Application by Norfolk County Council for Great Yarmouth Third River Crossing
The Examining Authority's written questions and requests for information (ExQ1)
Issued on 1 October 2019

DRAWING NUMBER
GYTRC-NCC-HGN-XX-DR-CB-1010

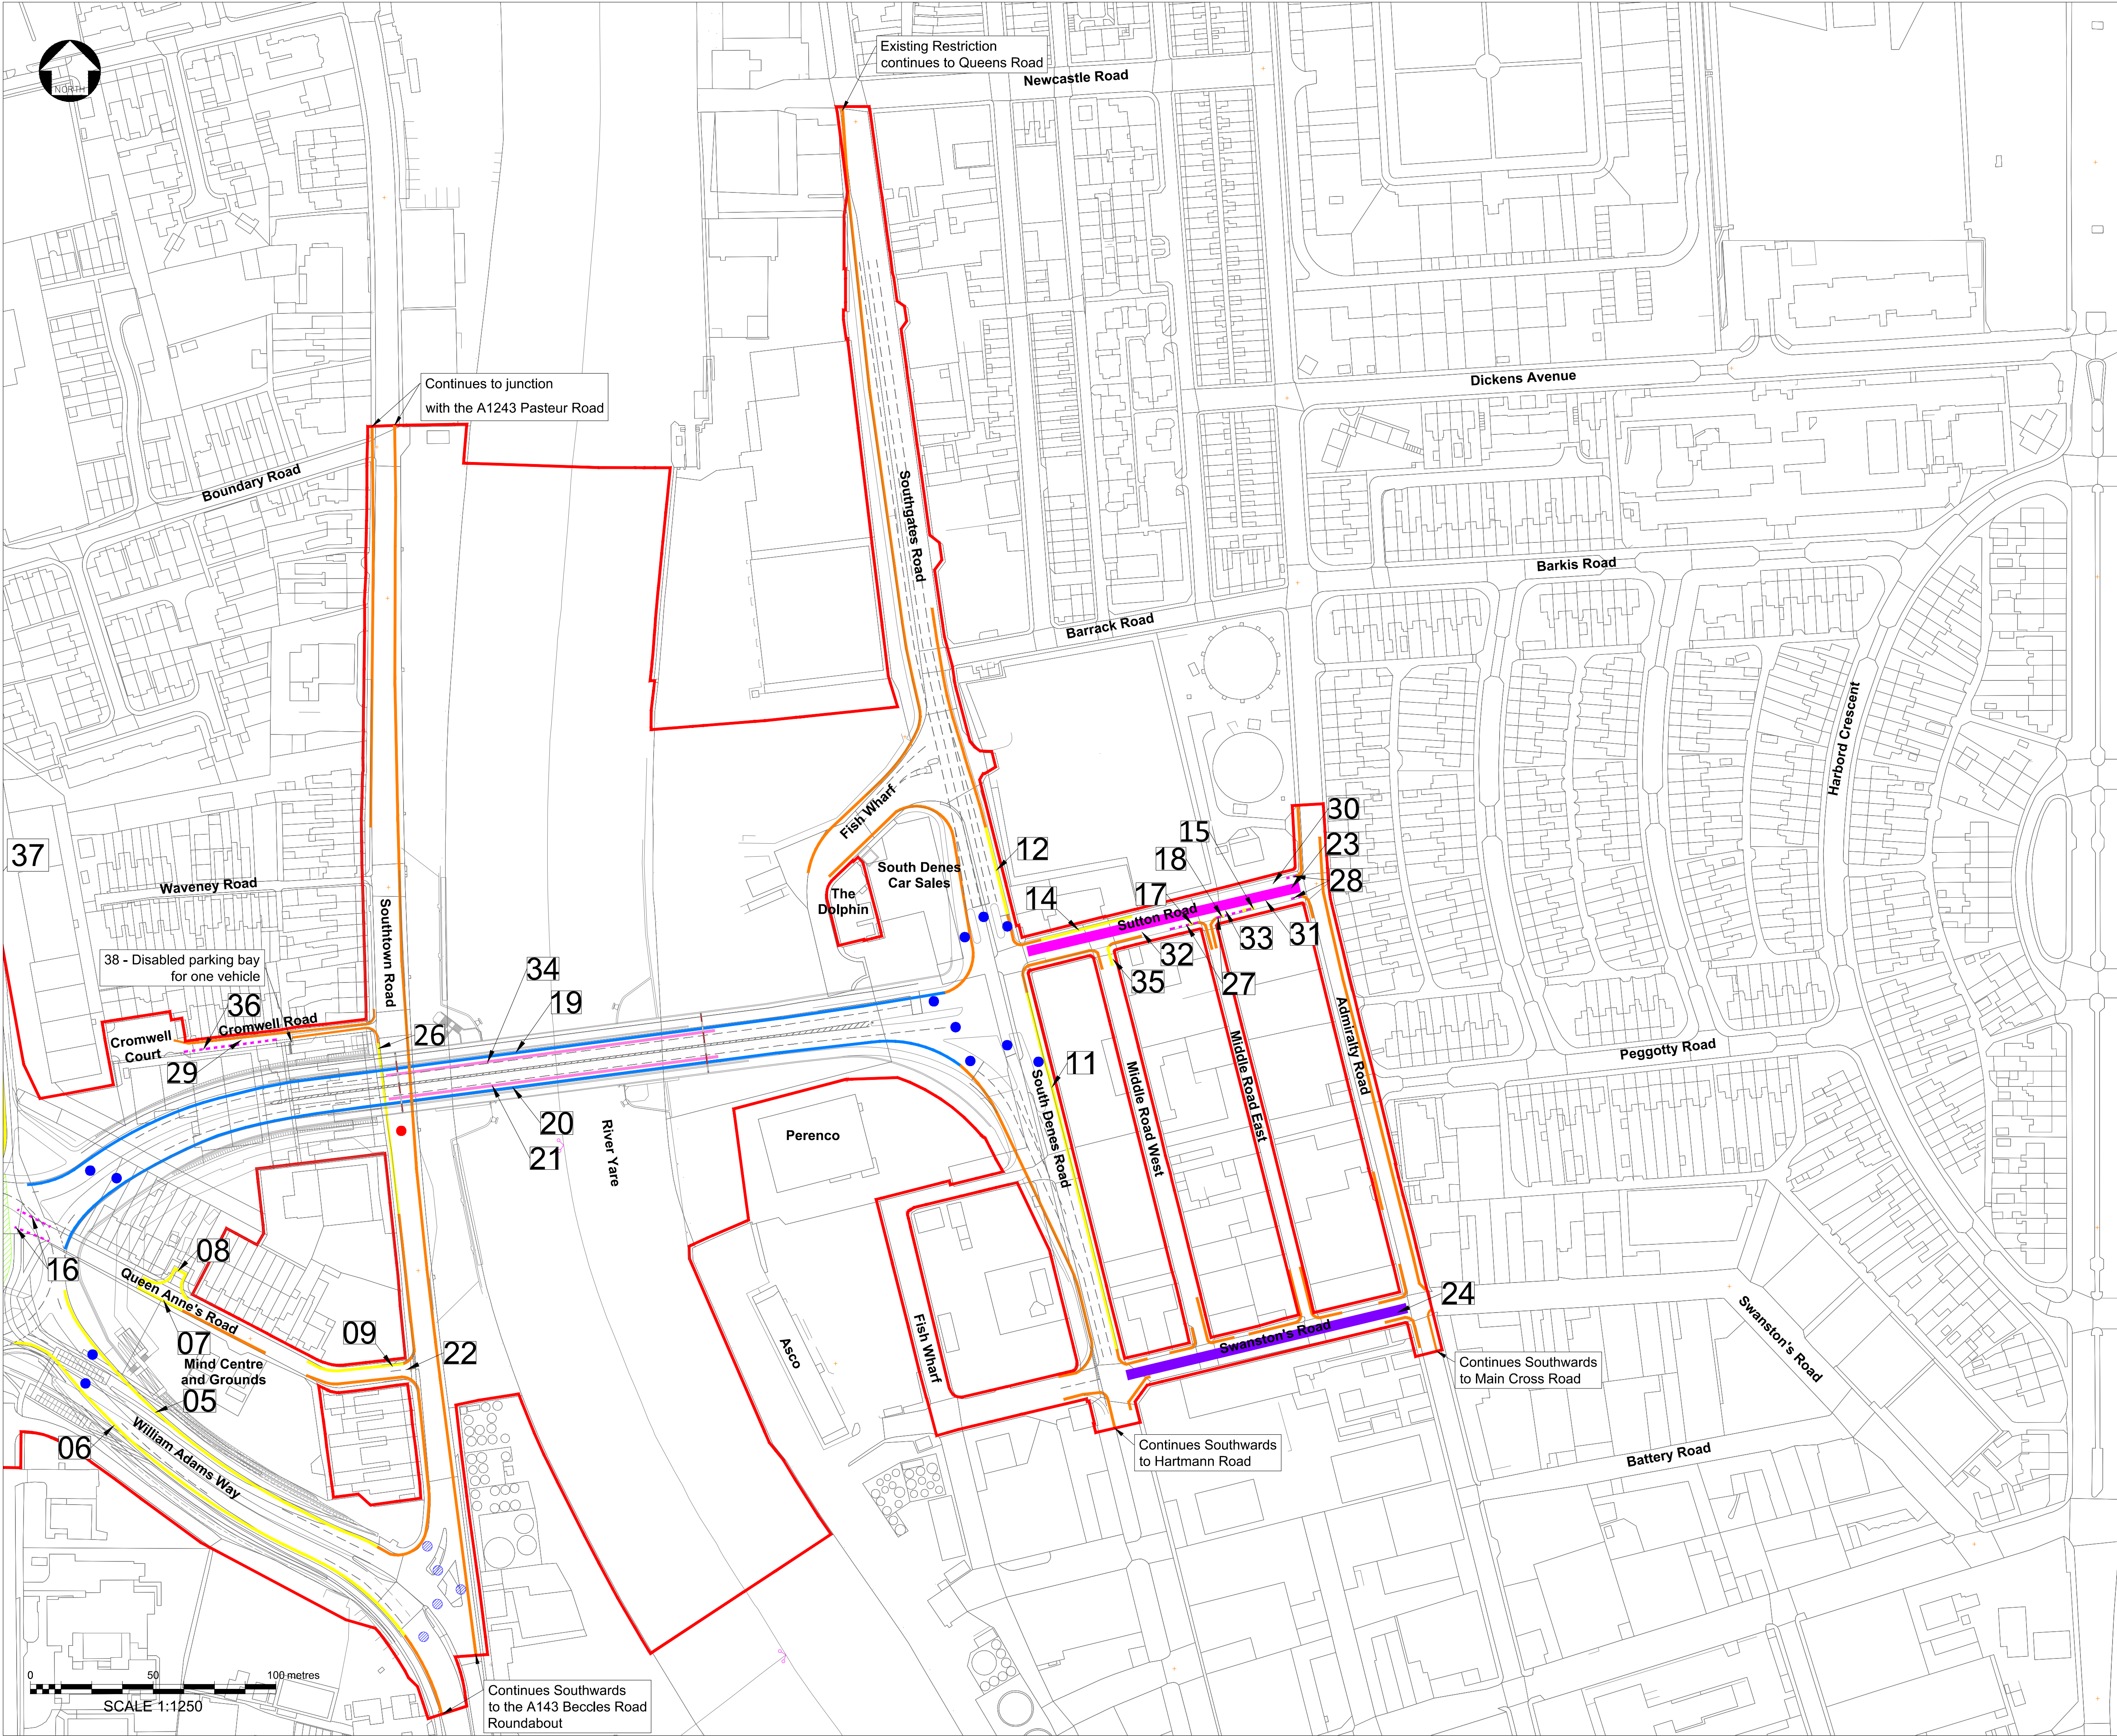
1.5.2.	Applicant	Please provide a specific justification for the extension of the no-waiting restrictions alongside the eastern side of Southgates Road north of the Barrack Road junction (Sheet 2 Reference 10) which is located some distance away from the proposed signalised junction.
